MIDTOWN COLLECTION AT HANNAH RIDGE
 COUNTY OF EL PASO, STATE OF COLORADO
 PUD DEVELOPMENT PLAN AND PRELIMINARY PLAN
 FILING NO. 1 AND FILING NO. 2

DATE	REVISION DESCRIPTION
4/3/19	Revised landscape plan due to revised grading walls and paving.
5/17/19	EPC comment revisions

JOB NUMBER: 2409-1218
 DATE: 3/20/19
 DRAWN BY: MB
 DRAWING DESCRIPTION:
TITLE SHEET
- LANDSCAPE
 SHEET #
L-TS 6 OF 13
© 2013 BY ALL AMERICAN • ALL RIGHTS RESERVED

JOB NUMBER	2409-1218
DATE	3/20/19
DRAWN BY	MB
DRAWING DESCRIPTION	LANDSCAPE PLAN
SHEET #	L-3
© 2013 BY ALL AMERICAN • ALL RIGHTS RESERVED

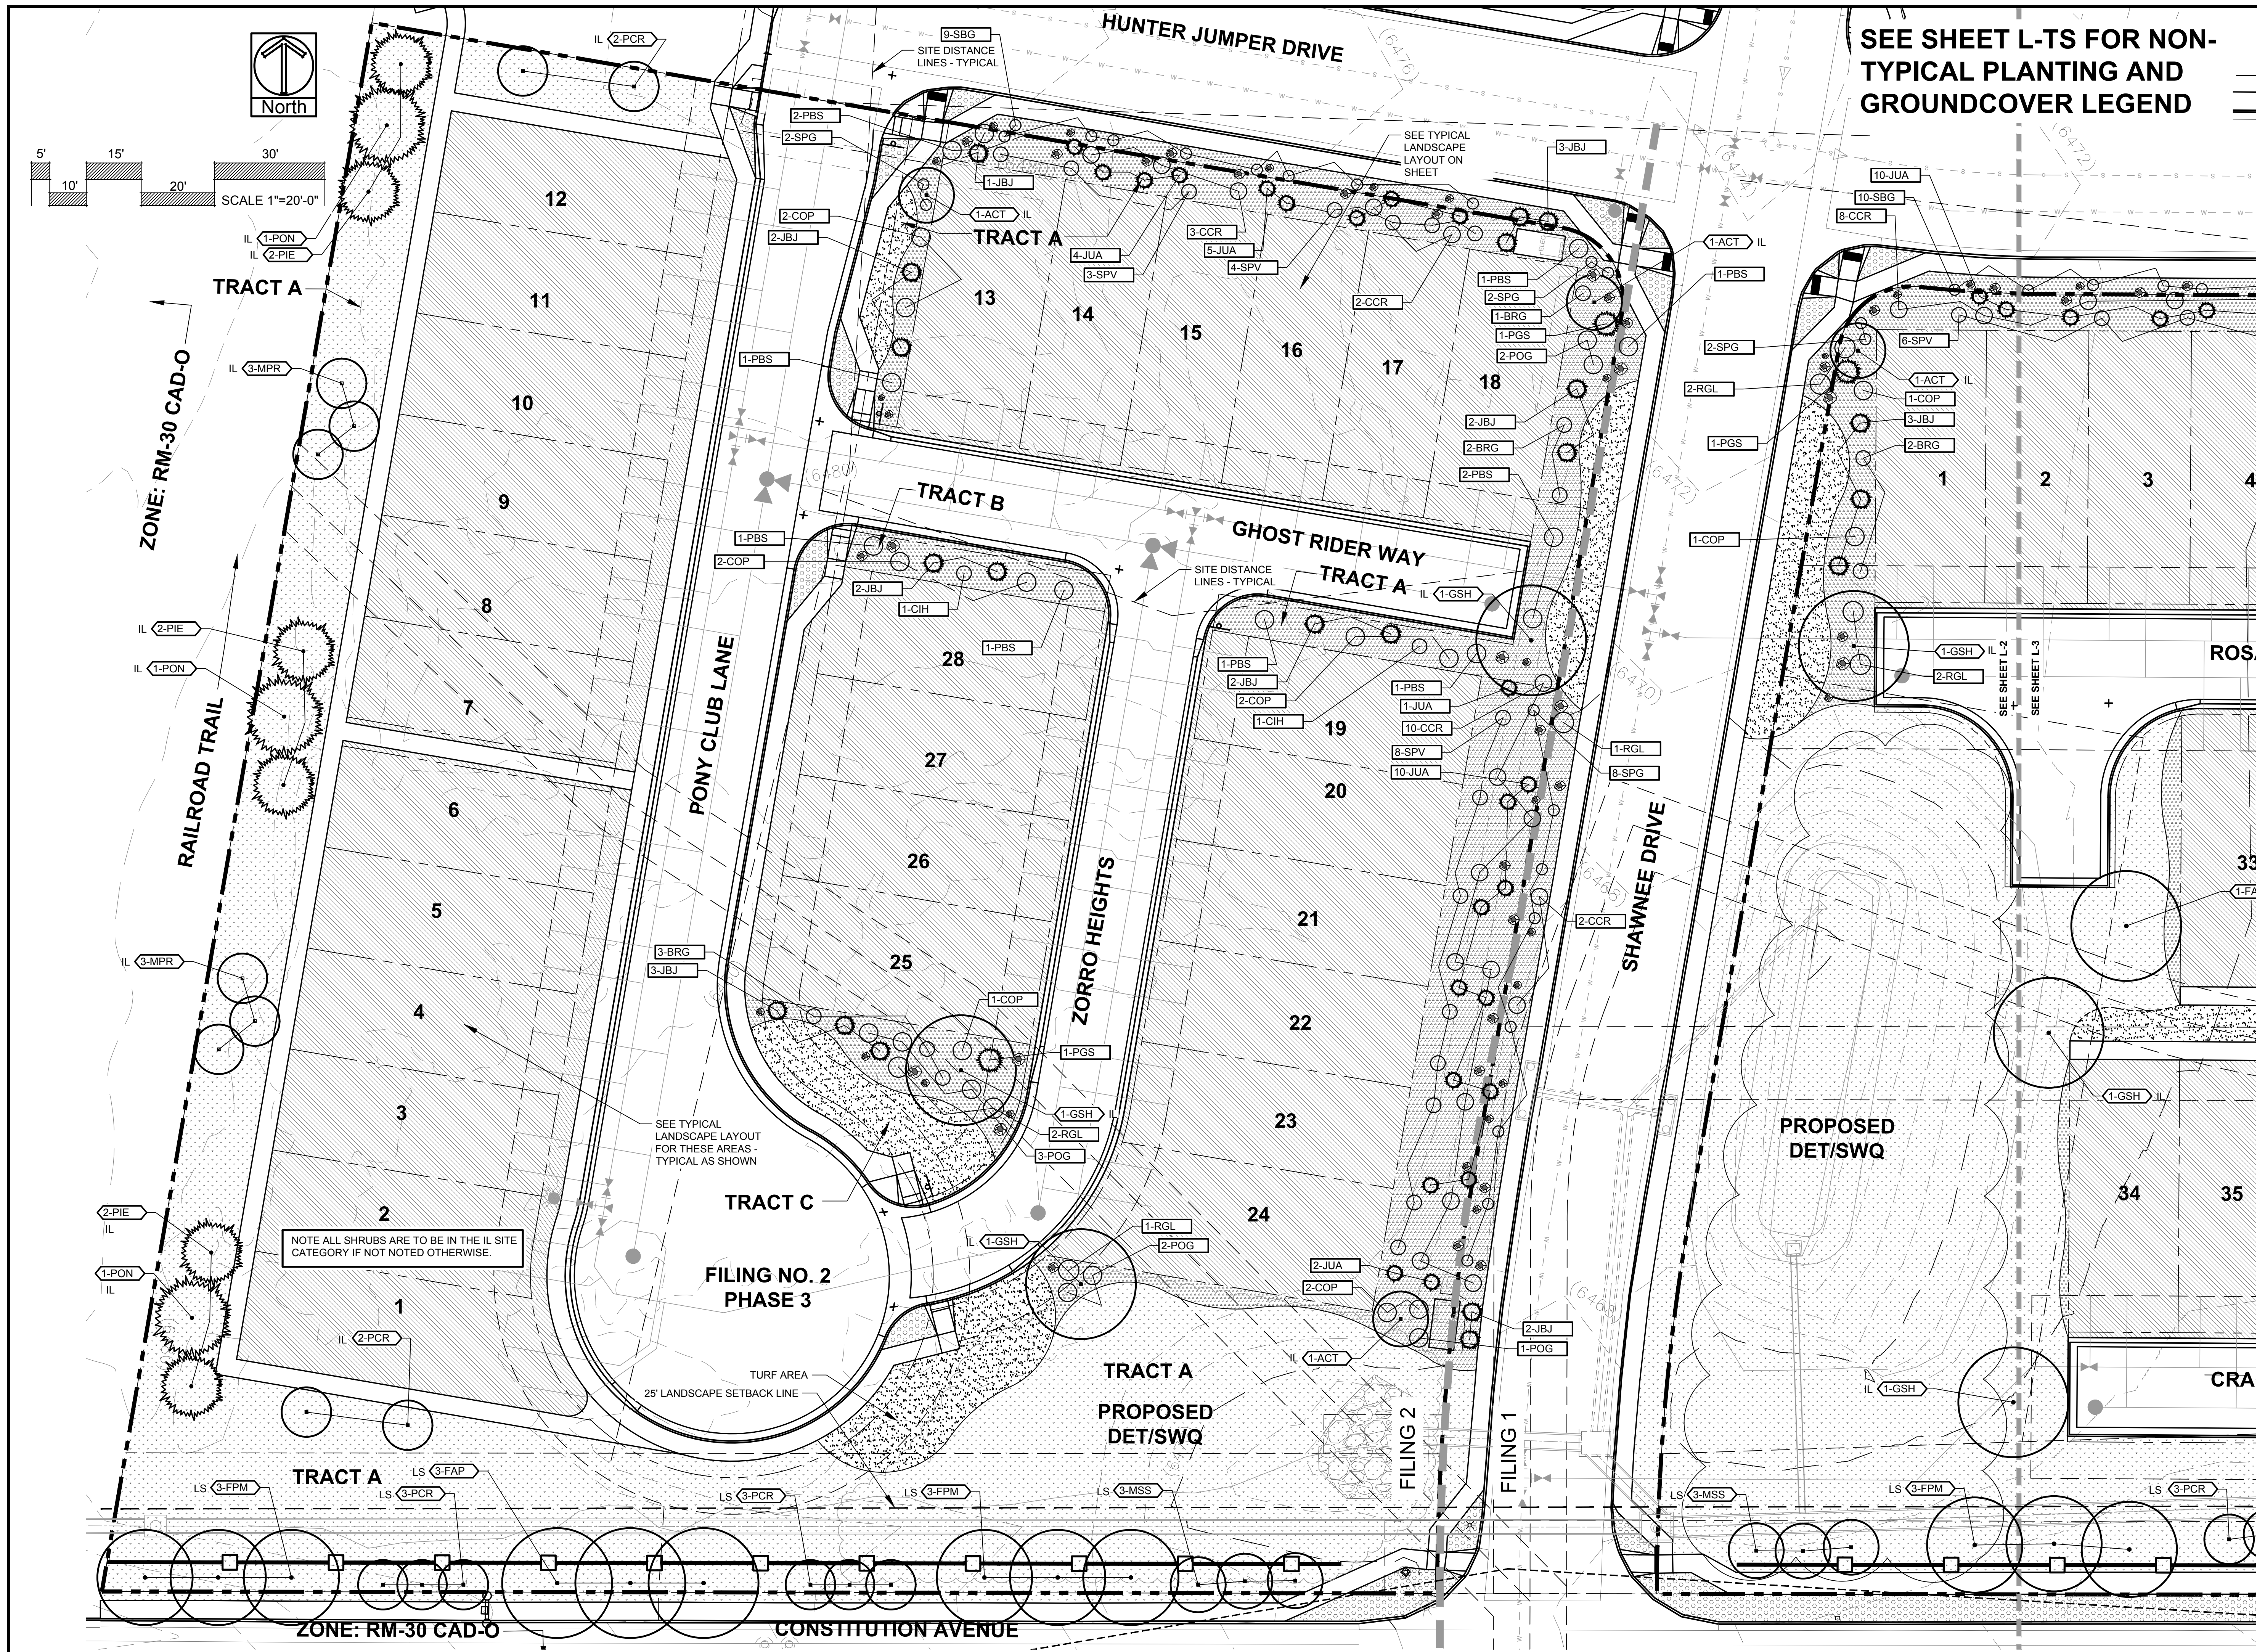
Did you move the trees into the ROW? A license agreement is required and the BOCC would approve that with this PUDSP.

Evergreen trees are not symbolized.

is there no wall to buffer commercial across street - See buffer REQ

C MONUMENT SIGN DETAIL
NOT TO SCALE

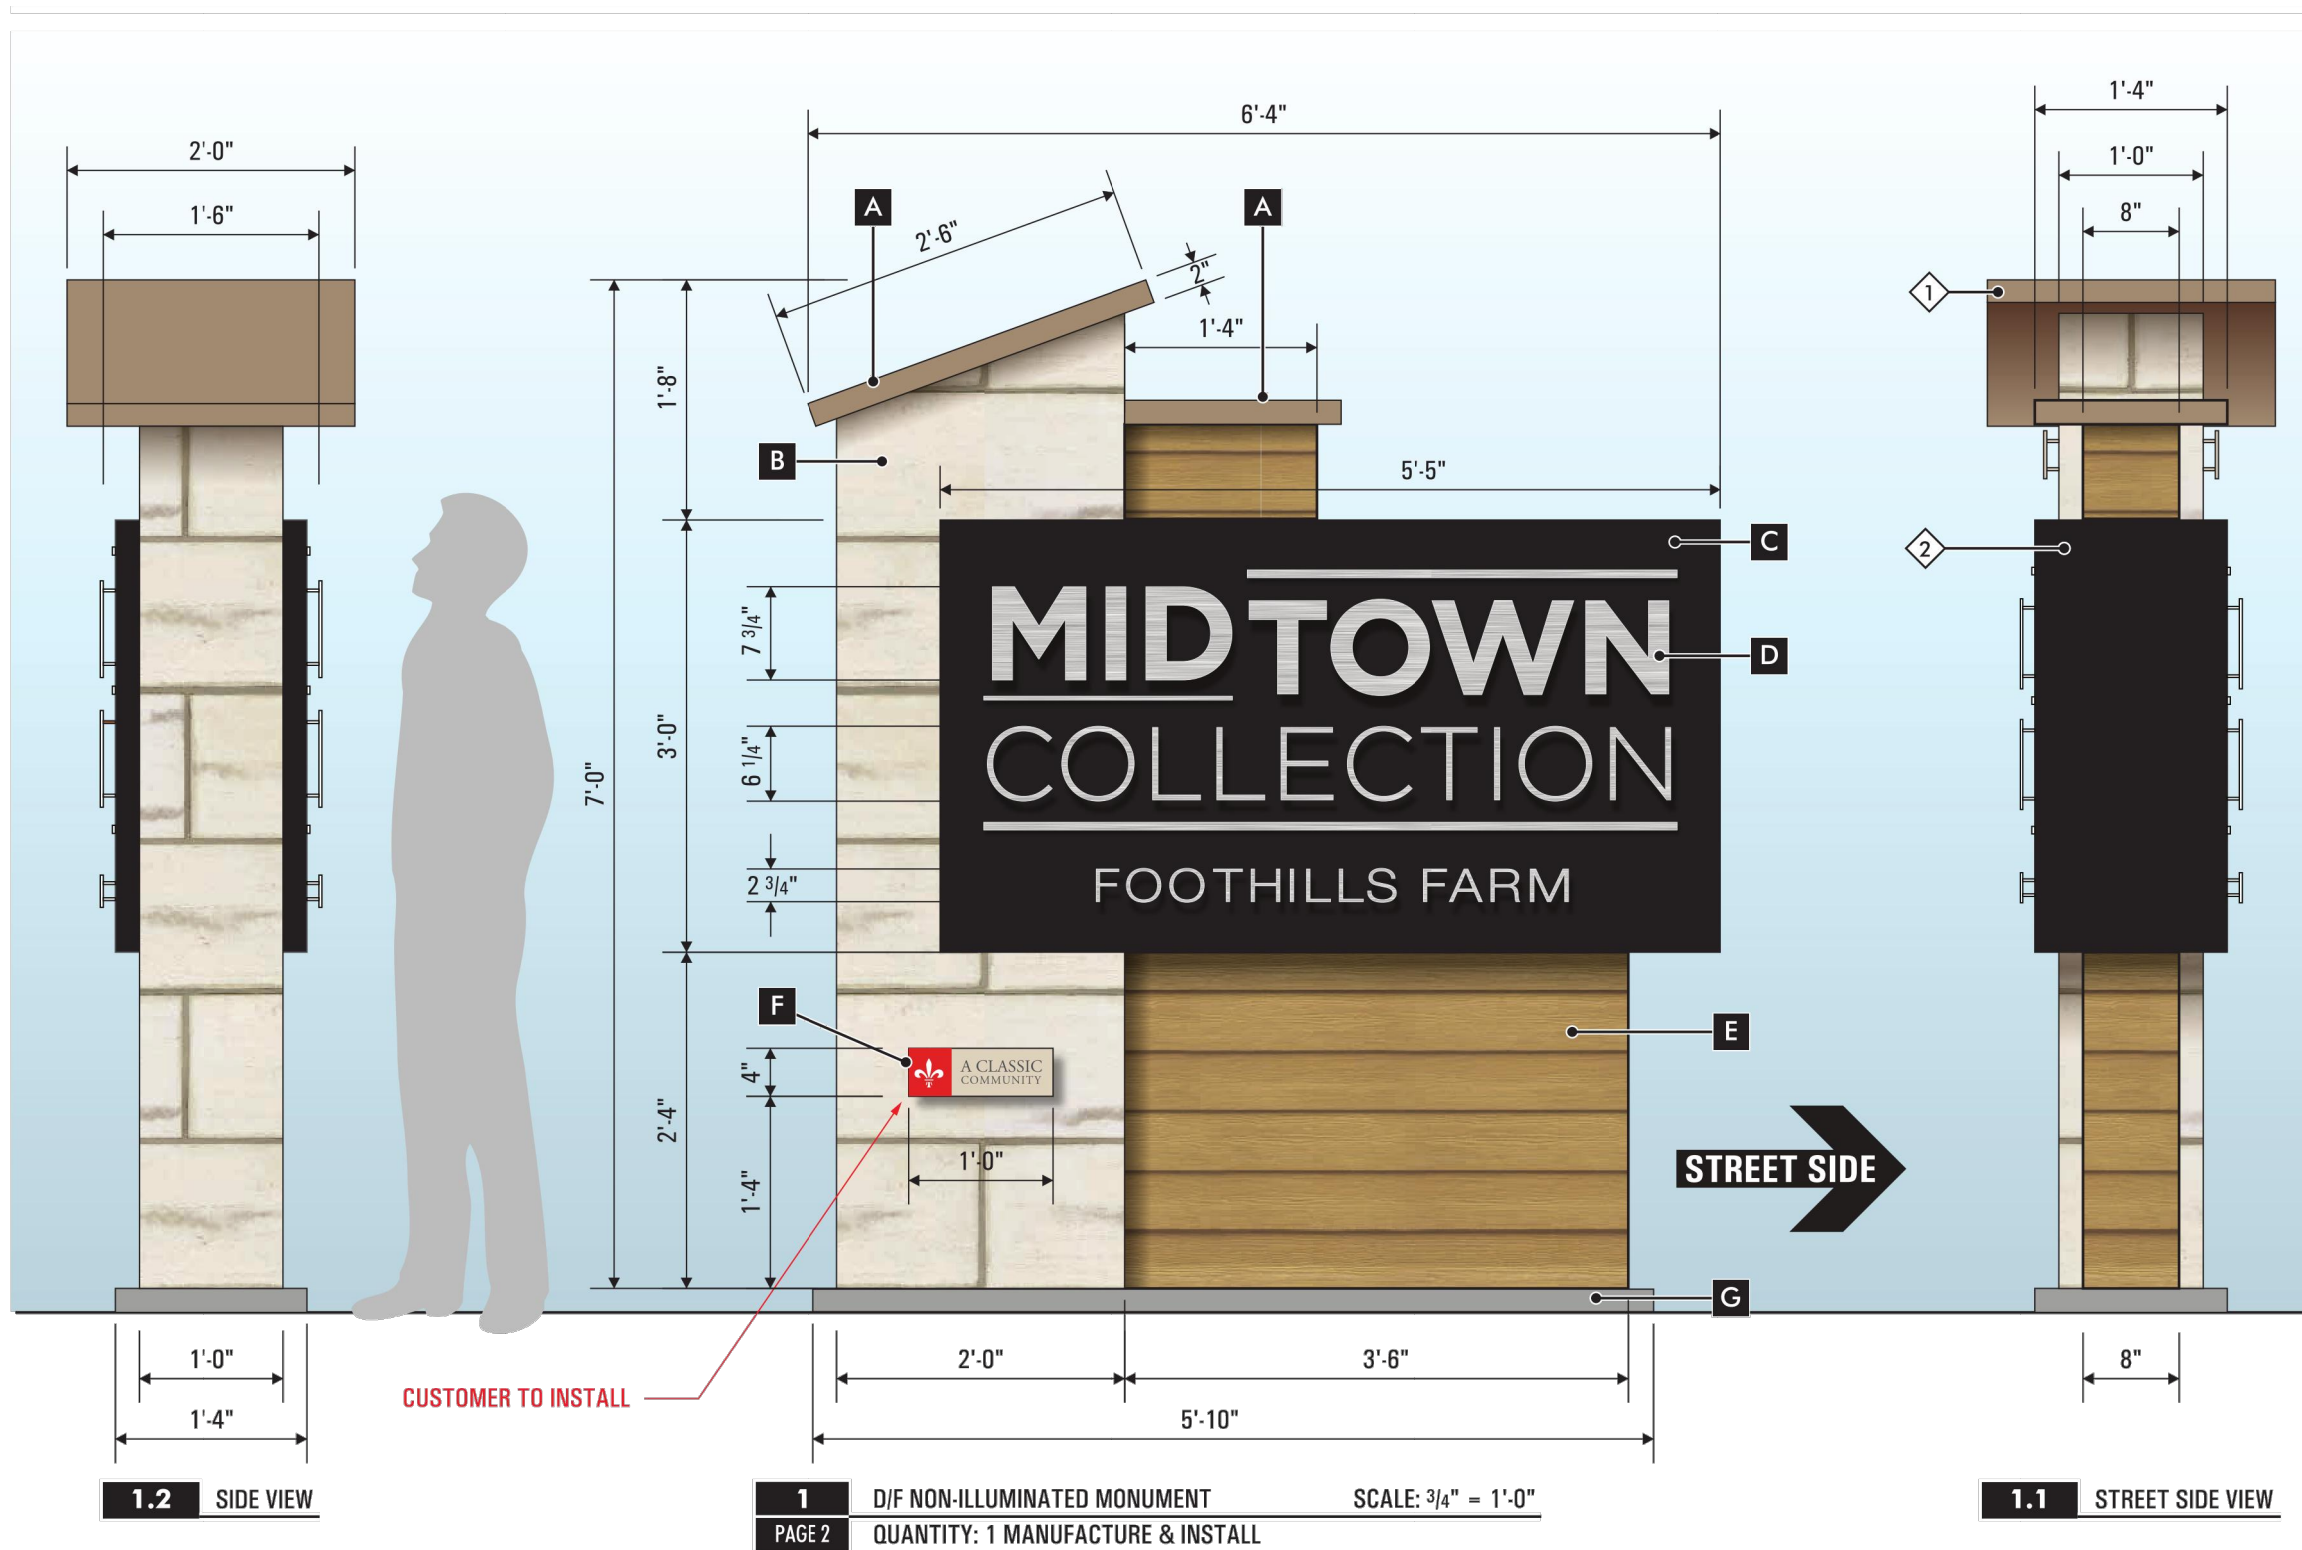
I think the name is wrong on the sign. Clearly mark where this sign is gong on the PUD plan set and LS.
